**Notice of Decision
Town and Country Planning Act 1990
Town and Country Planning (Development
Management Procedure) (England) Order 2015
Approval of Permission for Development**

Application No: 6/2022/2655/VAR

Development: Variation of condition 4 (approved plans) of planning permission 6/2022/1795/HOUSE

At Location: 133 The Ridgeway Cuffley Potters Bar EN6 4BG

PROPOSED 1F + ROOF PLAN

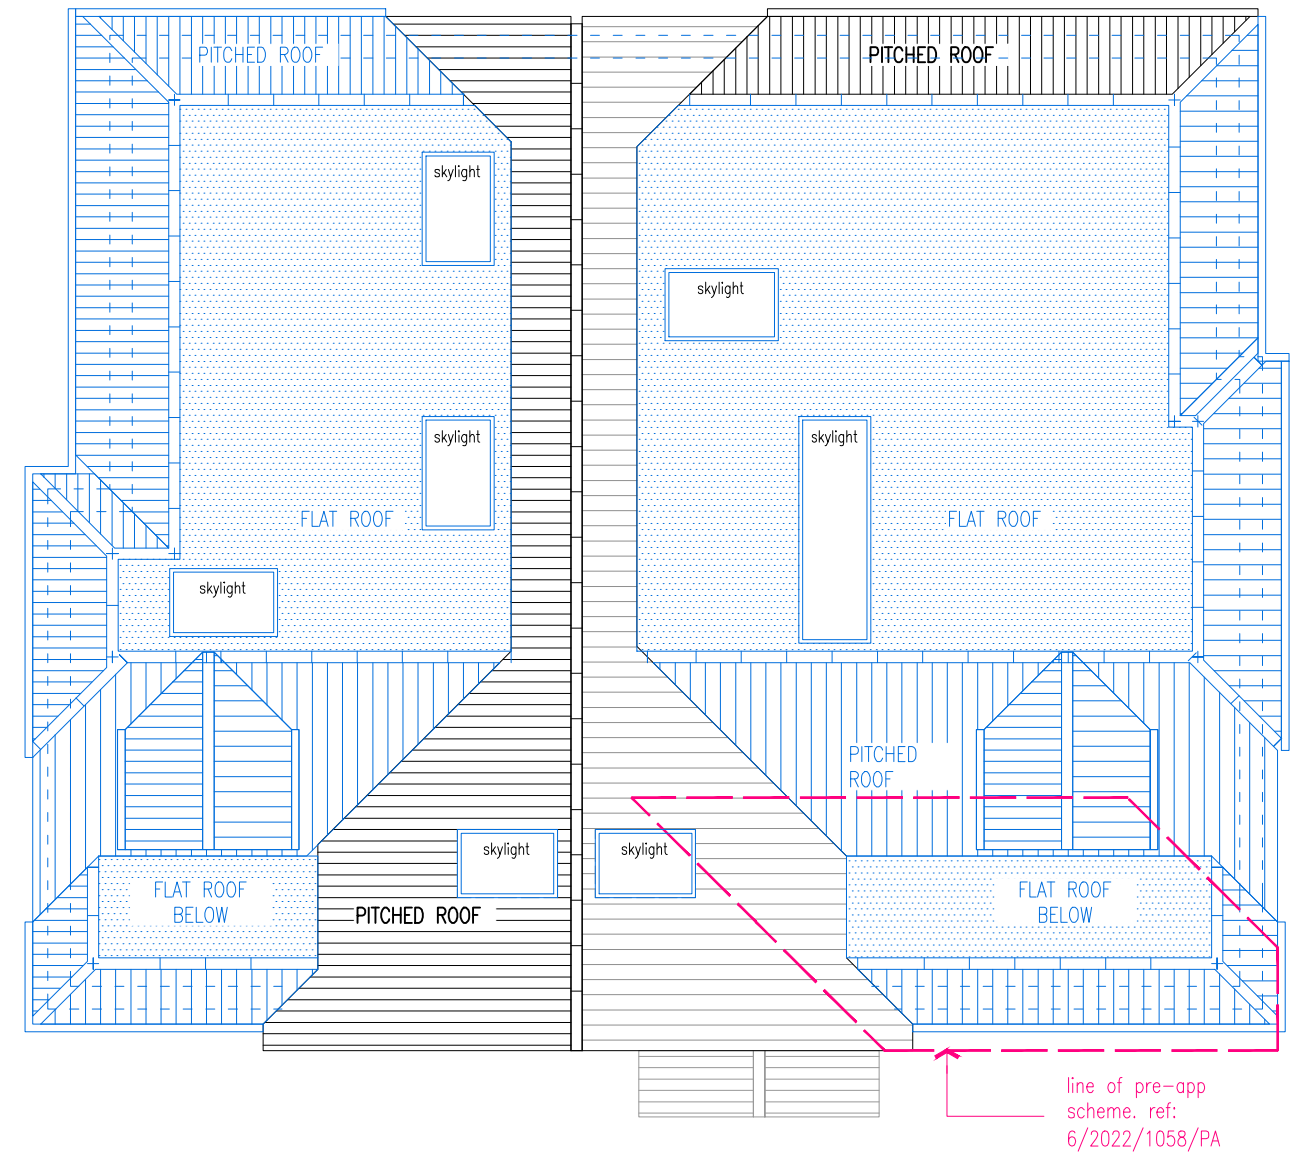
1. No development above ground level shall take place until details of the proposed crown roof, including a cross-section drawing, has been submitted to and approved in writing, by the Local Planning Authority. Subsequently the development must not be carried out other than in accordance with the approved details.

- The upper floor window located in the flank elevation of the dwelling facing towards No. 131 hereby approved must be obscure-glazed and non-opening unless the parts of the window which can be opened are more than 1.7 metres above the floor of the room in which the window is installed, and shall be retained in that form thereafter.
